Re: 2026/90946- Discharge of details reserved by conditions 5 , 6 , 7, 8 (Demolition Works), 9 (new walls/other structures), 14 (electricity substation), 18 (Phase II Intrusive Site Investigation Report), 23 (drainage), 24 (new building retaining walls), 25 (CEMP), 28 (cycles), 30 (evc), 34 (retained walls), 35 (Mitigation Method Statement), 36 (PWMS), 37 (CEMP: Biodiversity), 38 (BEMP), 40 (security and crime prevention measures), 41 (landscaping) on previous permission 2025/91122 for Redevelopment of site for mixed-use E(g) (i, ii and iii) and B8 including: demolition of buildings and re-cladding of southern elevation of retainer adjoining building; retention, conversion and renovation of existing mill/office/workshop/engine house building including alterations; erection of two new buildings; formation of two vehicular access points, service yard and parking areas; and other associated works

Condition 28- cycles

# Wardale® Cycle Shelter

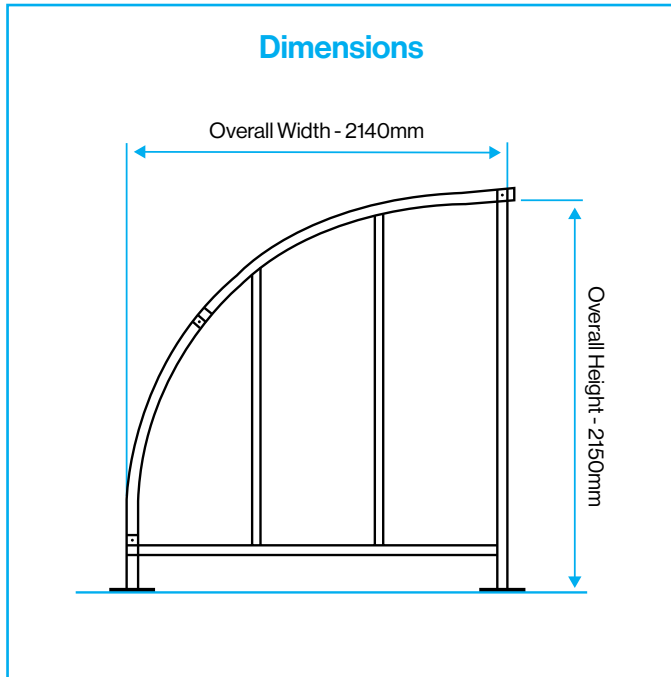
I have reviewed Drawing 3310 76 dated Mar 2026 relating to the Proposed Cycle Shelter. The shelter is acceptable. However, I cannot identify any details of security ratings for the storage devices located inside. The recommended minimum standards are: Sold Secure SS104 Silver, LPS 1175 Issue 8 Security Rating B3, LPS 2081 Issue 1 Security Rating B, STS 225 Issue 2 Burglar Resistance BR2(S), STS 205 Issue 8 Burglar Resistance BR2, STS 501 Security Rating TR2 or STS 503 Security Rating TR2.
